From: Simon Davis
Sent: 02 April 2019 11:34
To: 'Tom Edmunds' [REDACTED]
Subject: RE: Planning Consultation on: BR/39/19/PL

BR/39/19/PL - Application for Variation of Conditions following the grant of Planning Permission BR/240/16/PL relating to Condition 2 & Planning Permission BR/331/17/PL relating to condition 1 - approved plans

title: Proposed Sections

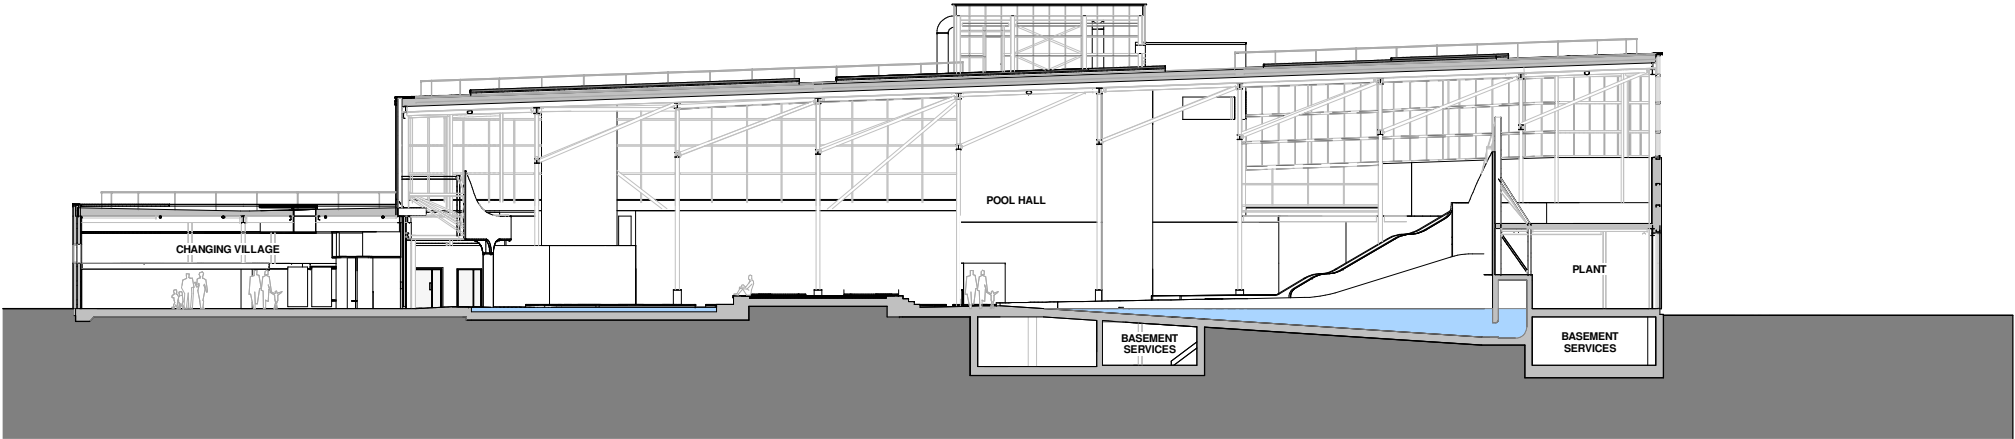
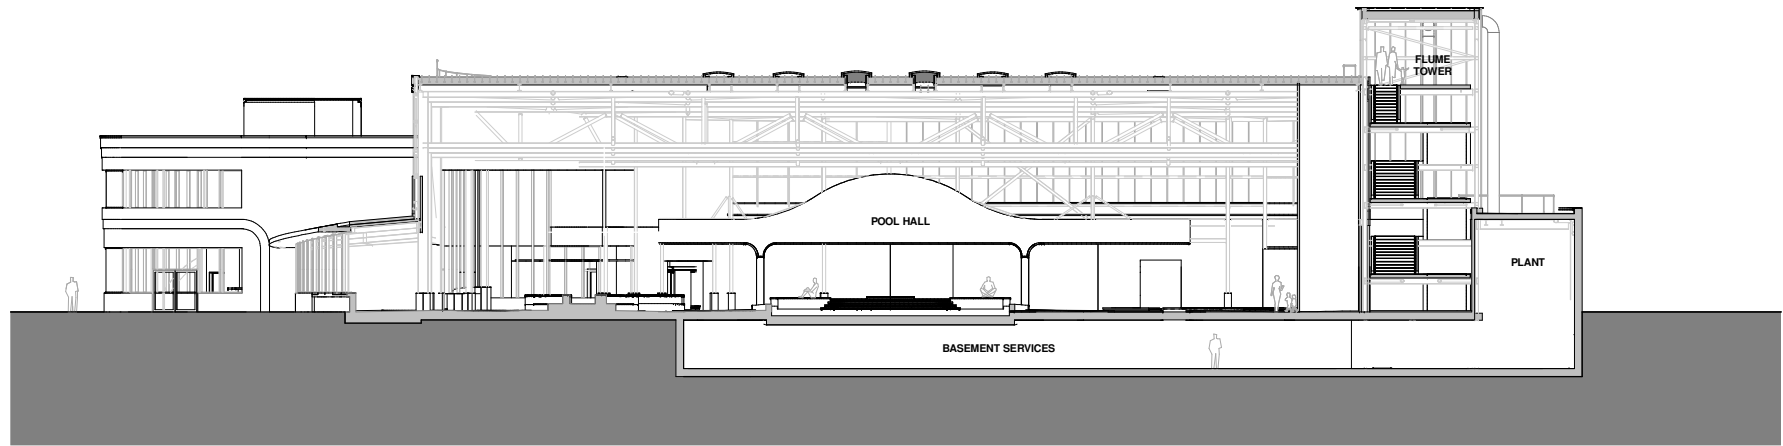
Please see comment below from Environmental Health. Can you advise re whether the amendments to the flume height and the rapid river design will have any adverse impact on the acoustic environment.

I note from the covering letter submitted with the application that it includes amendments to reduce the height of the flume, adjustments to the design of the rapid river and addition of louvres. They have stated that the louvres will have no impact on the acoustic performance of the building. However, I would request that the applicants also ask their acoustic consultant to confirm that the amendments to the flume height and the rapid river design will have no adverse impact on the acoustic environment. If this is the case then environmental health would have no objection to the amendments.

Attached is an email from the acoustic consultant (who prepared the original 2016 report) providing confirmation that his conclusions do not change. That is, the minor amendments to the flume height and the rapid river design proposed by this application will have no adverse impact on the acoustic environment.
